Viewpoint Estates, Filing No.2, Preliminary Plan (Minor), SP-21-5

Please accept the following comments from El Paso County Public Health regarding the project referenced above:

**PRELIMINARY PLAN
VIEWPOINT ESTATES
FILING NO. 2**

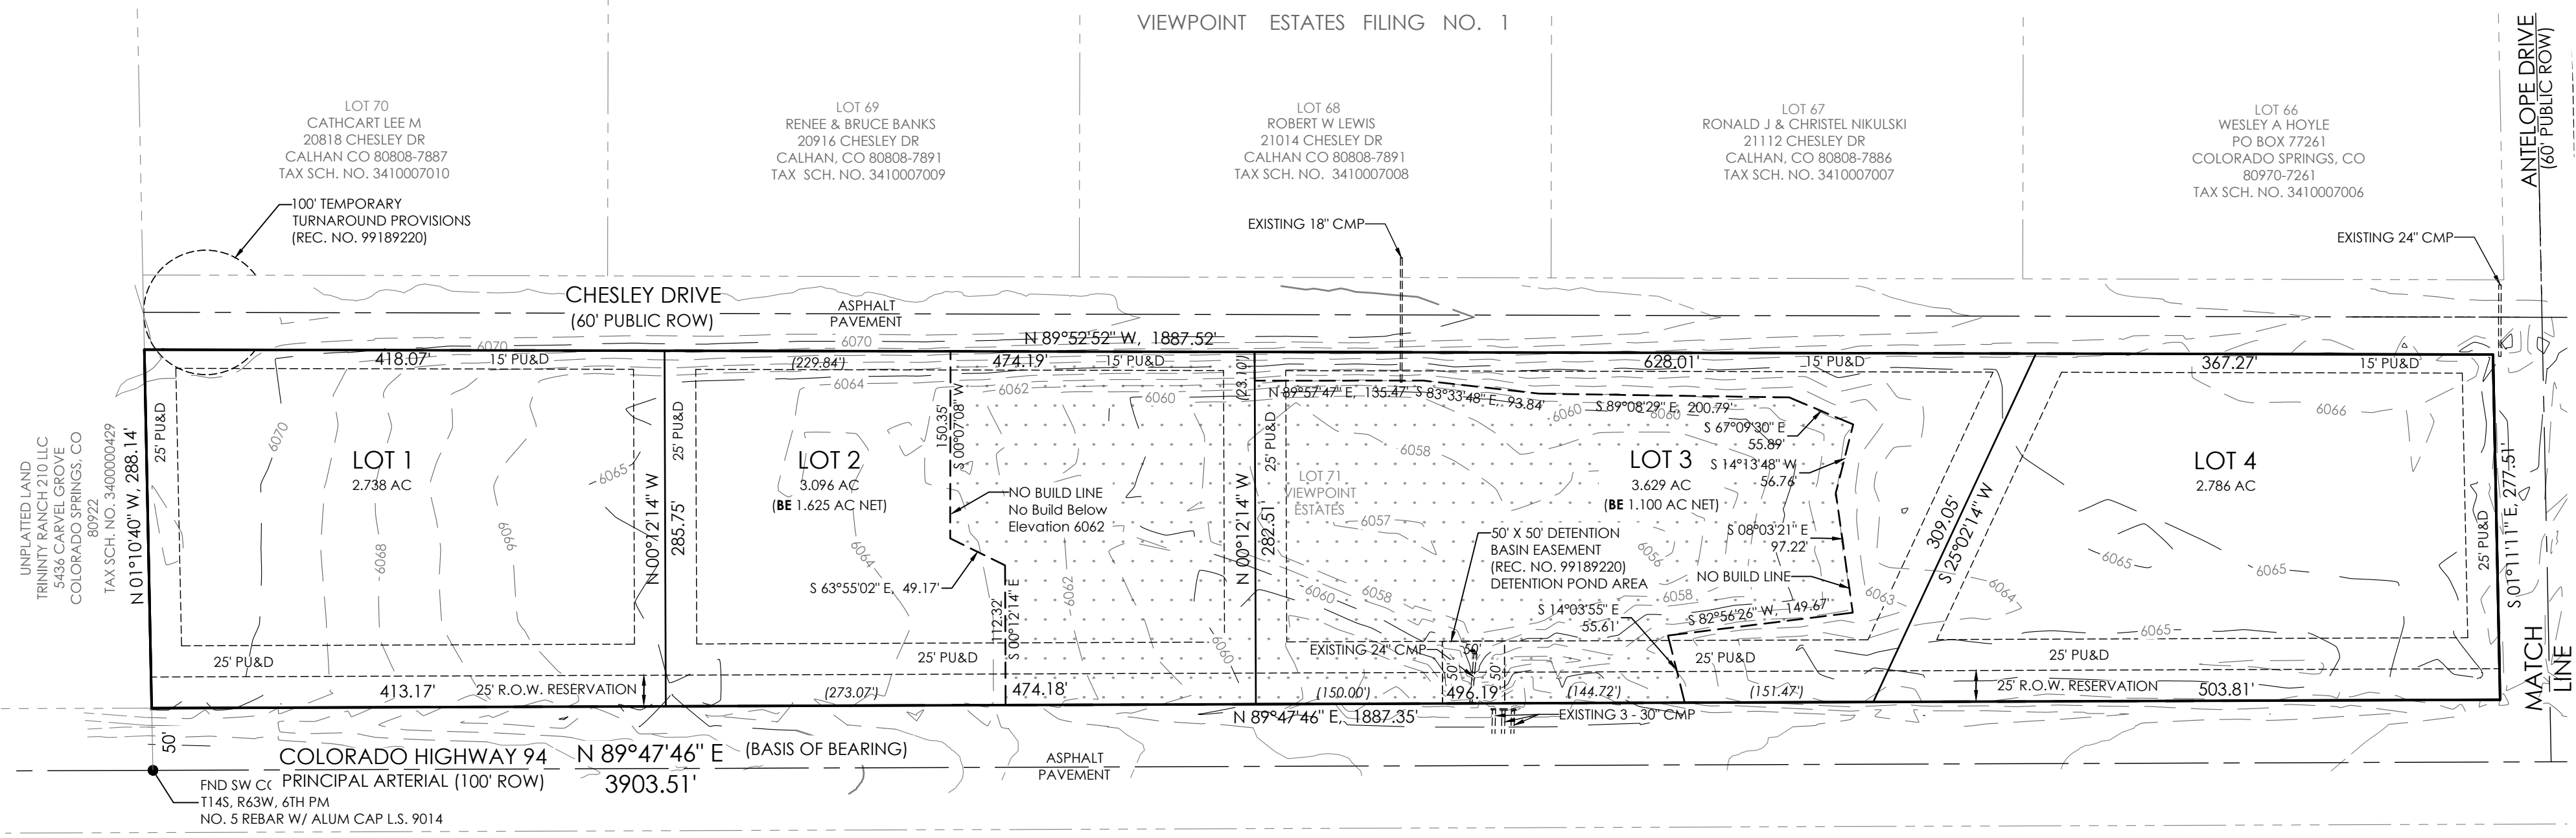
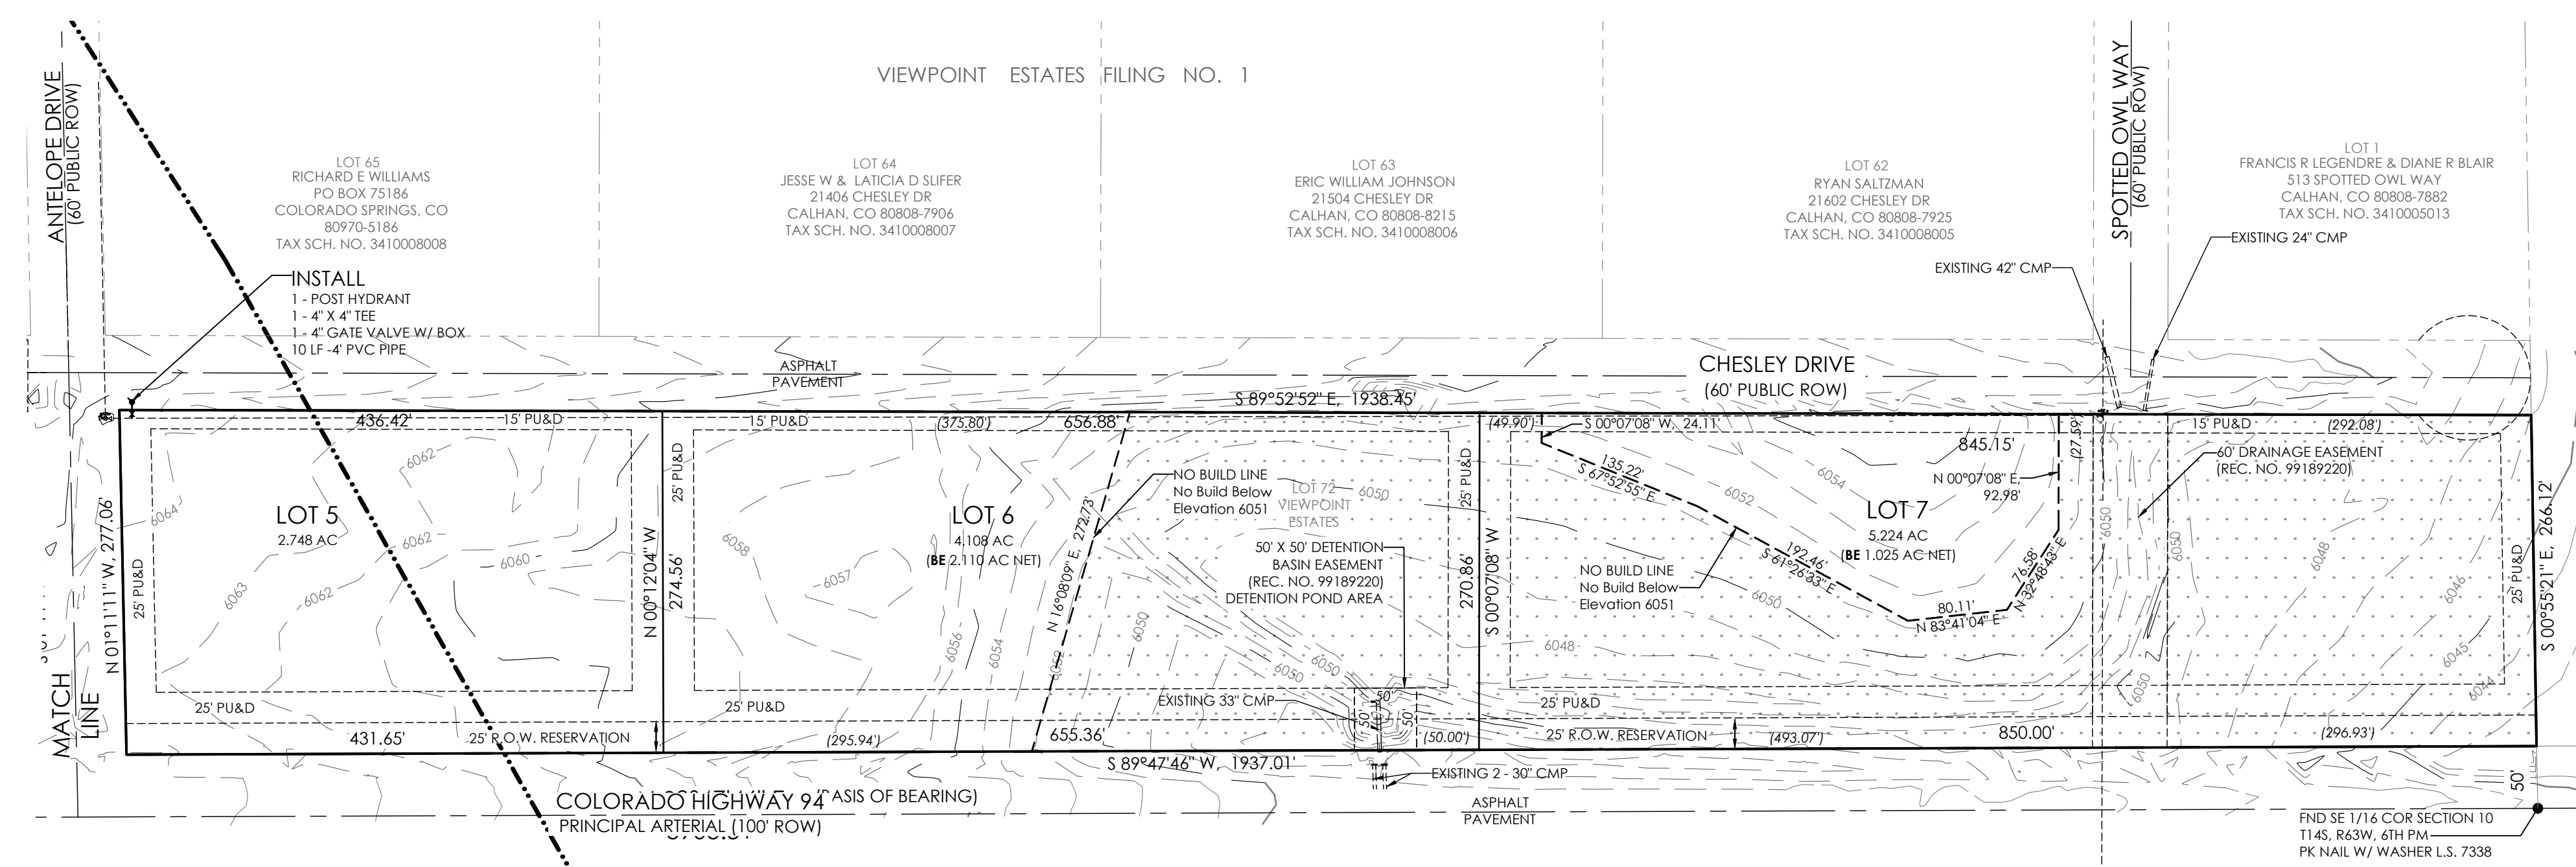
- **The 14October2021, Entech Engineering Soil, Wastewater Study Report, and The Entech Engineering Soil, Geology, Geologic Hazard, and Wastewater Study Report were reviewed to determine the feasibility of using wastewater treatment through onsite wastewater treatment systems (OWTS). The referenced reports support the use of onsite wastewater treatment systems for this proposed development project. All onsite wastewater treatment systems must comply with Chapter 8 of the El Paso County Board of Health Regulations. Each individual lot requires soil profile test pit excavations in the proposed soil treatment areas as part of the permitting process by El Paso County Public Health. Planning the location of the house footprint, driveways, out-buildings, and primary and secondary soil treatment area locations on each lot is critical. Dry gulches, a detention basin, drainage ways, and no-build areas are variables to watch during lot development especially on lots 2, 3, 6 and 7.**
